Rezoning Transportation Analysis
Petition Number: Insert Zoning Petition #2022-027
General Location Identifier: 18317703

From: Jake Carpenter, PE
Jacob.Carpenter@charlottenc.gov
980-221-5675

Date	Description
07-28-2022	First Review (AO)
08-19-2022	Second Review (WB)

SHEET NUMBER **RZ-1**

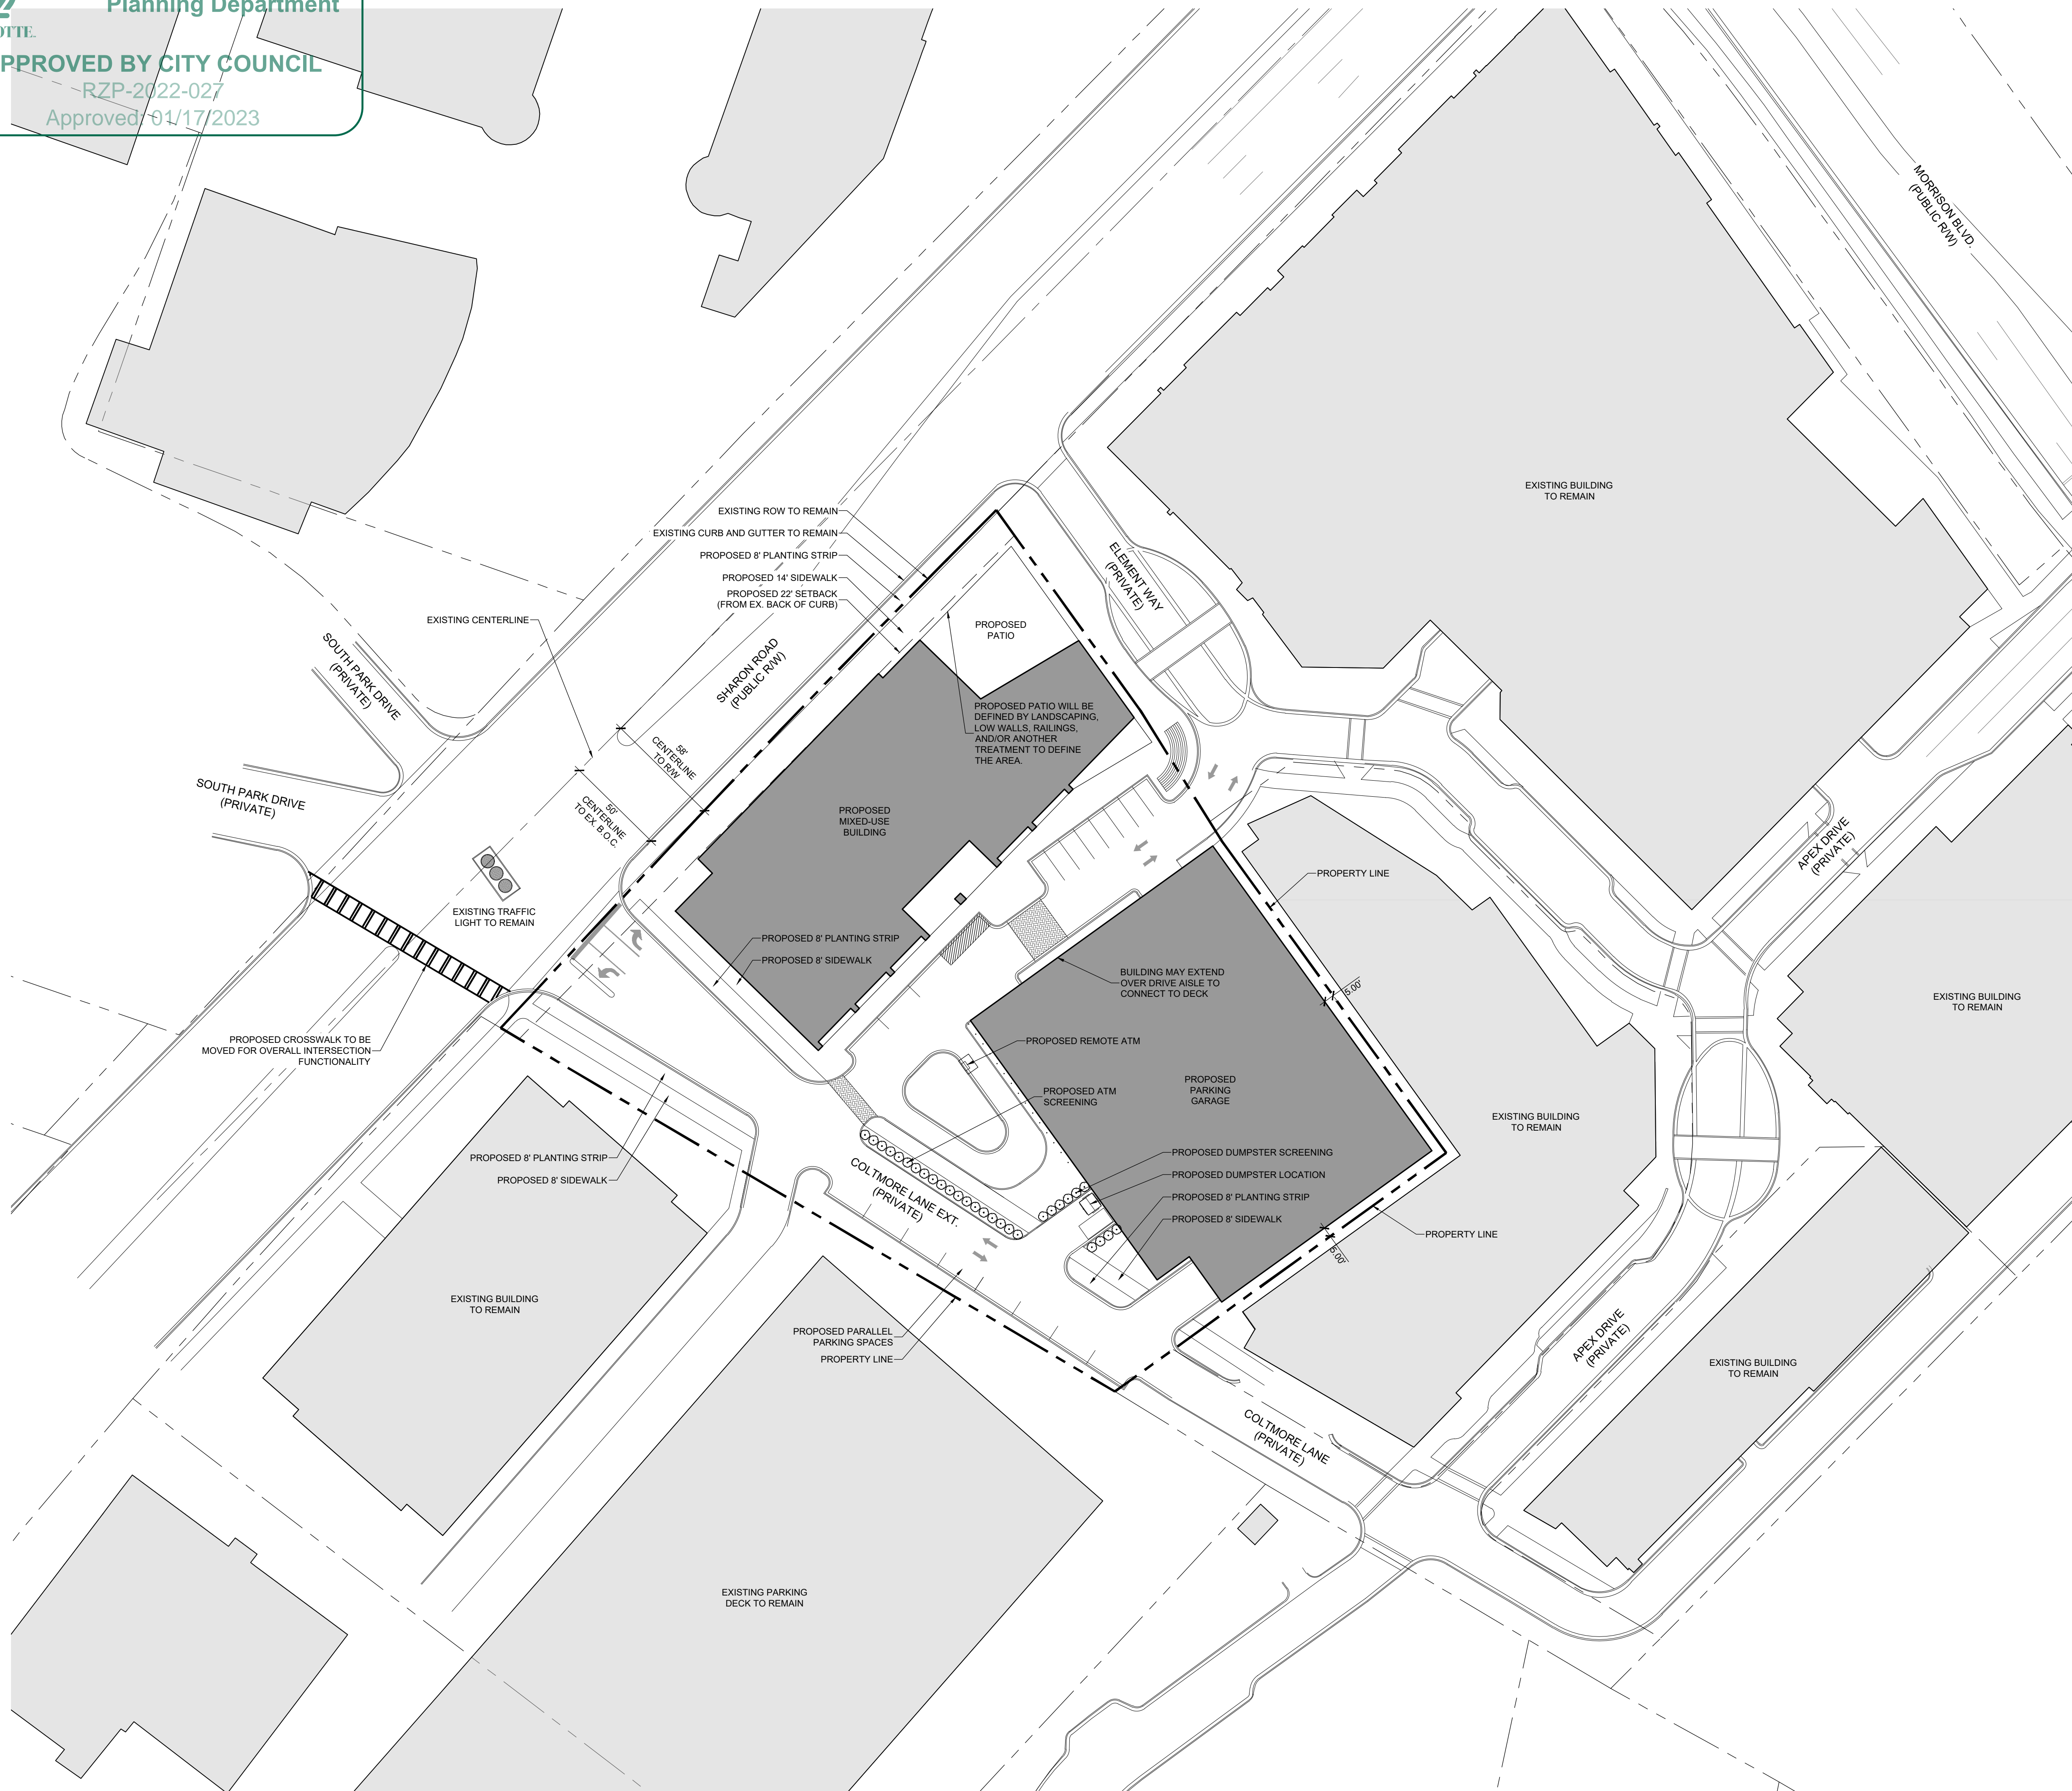
1. **Curbline:** ~~The proposed zoning district has a setback measured from back of the existing or proposed future curbline.~~
 - a. **Sharon Road:** ~~Future back of curb and gutter to be placed 44 feet measured from Sharon Road centerline.~~

Label and dimension the curb and gutter from the centerline for each road on the site plan.
2. **Traffic Study:**
